Historic England

Our ref: P00696890

**T&CP (Development Management Procedure) (England) Order 2015
& Planning (Listed Buildings & Conservation Areas) Regulations 1990**

**HEYFORD PARK CAMP ROAD UPPER HEYFORD BICESTER OXFORDSHIRE
OX25 5HD
Application No. 17/02006/REM**

CHARACTER AREA 7 - CORE HOUSING WEST

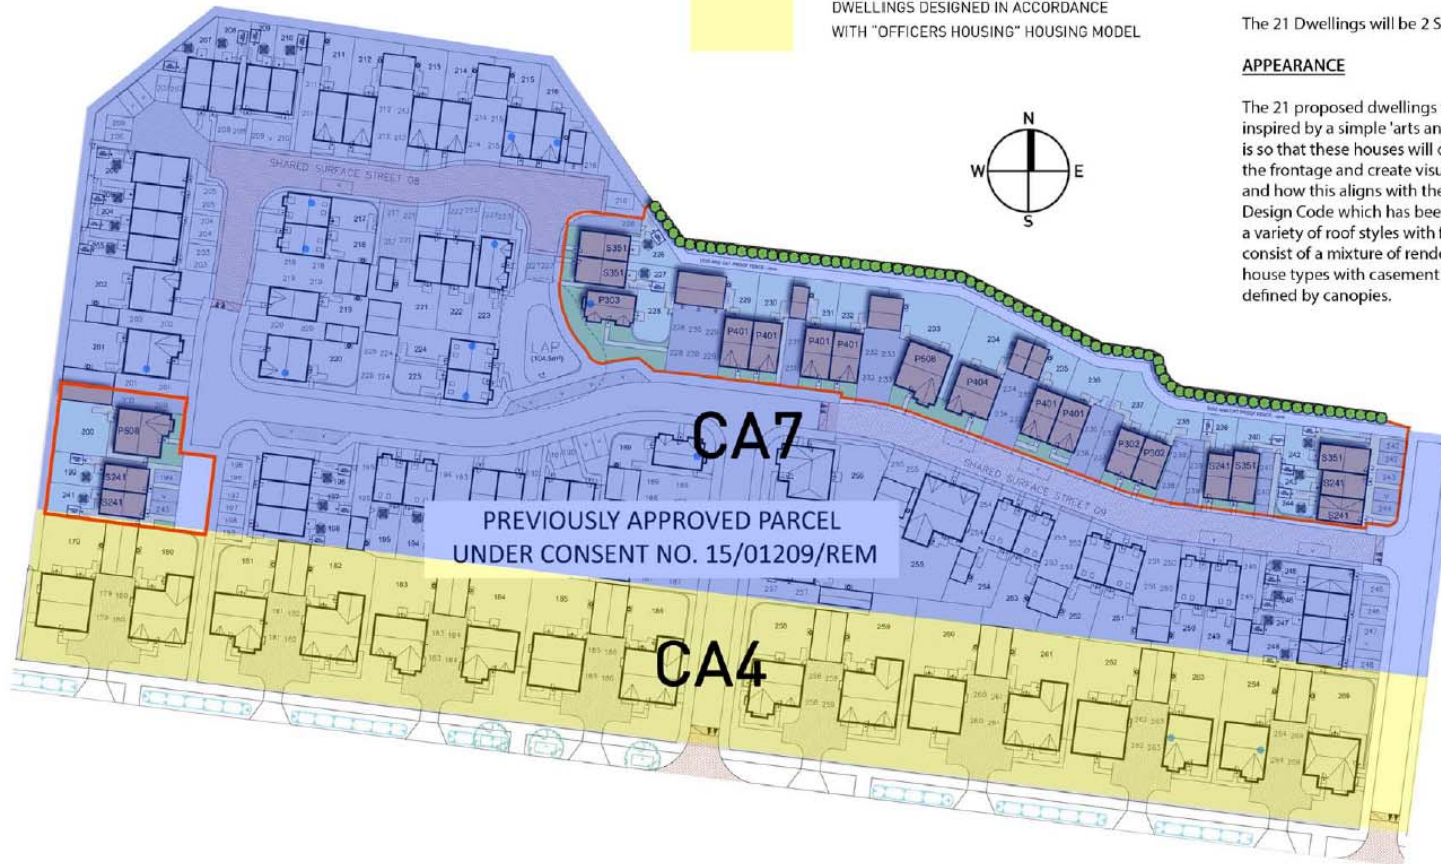
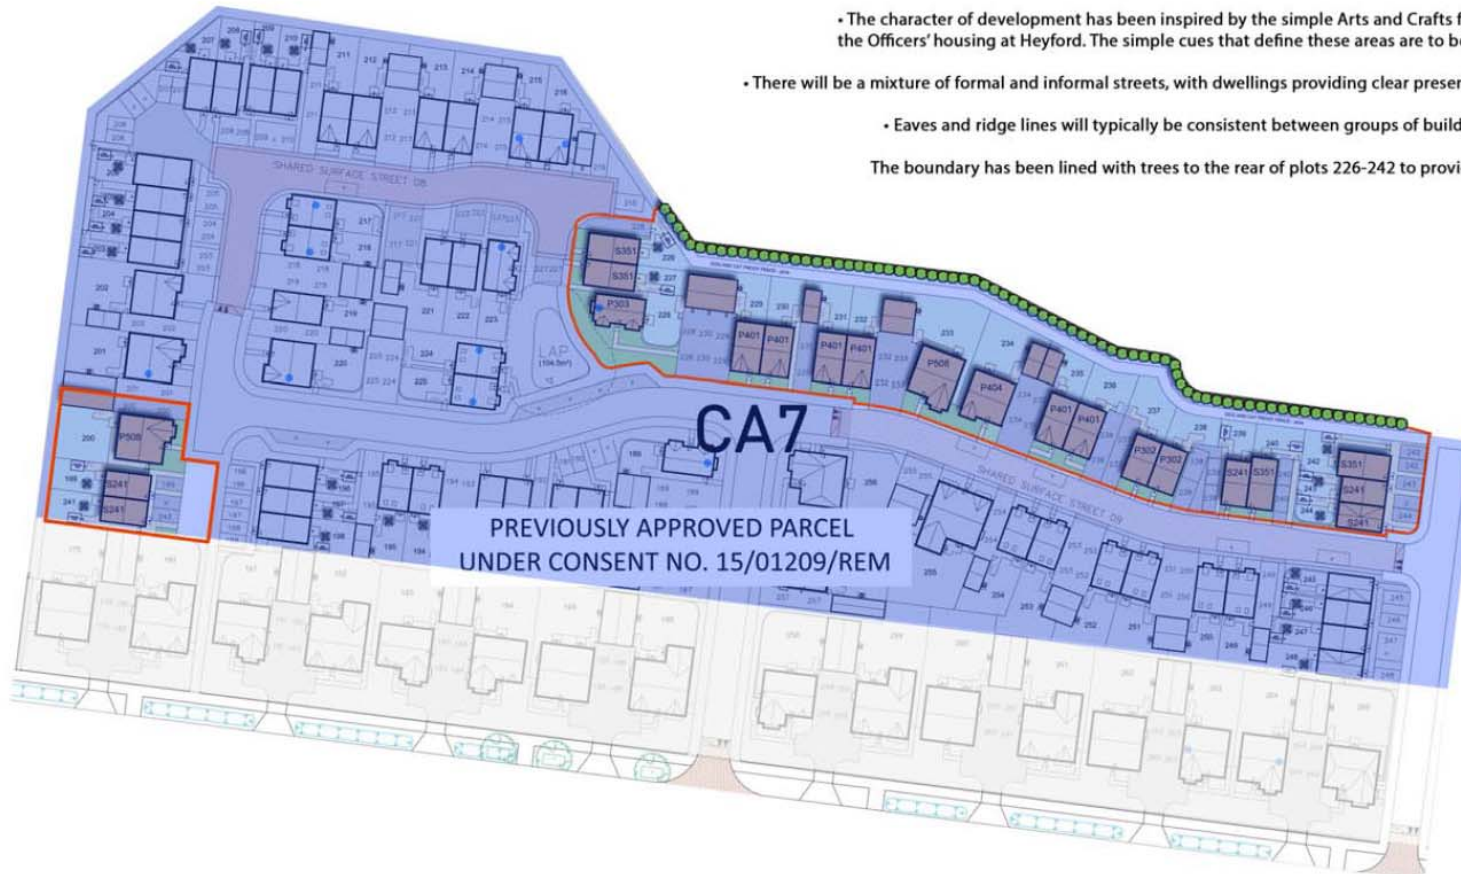
The current application seeks reserved matters approval for those previously omitted units, this time with a buffer strip of planting indicated along the northern site boundary. We welcome the addition of a planting screen. We nonetheless question how effective it would be given the narrow margin that has been allowed for it. To achieve the necessary visual buffer between the proposed housing and the nose docks, and to avoid the harm to the significance of the listed buildings and conservation area as described in our letter of 14 August 2015, this tree screen would

need to be both tall and dense, and probably including some evergreen element. We are not persuaded by the information currently provided that this would be the case, so would therefore urge you to seek further details and amendments to address this concern before the current application is determined.
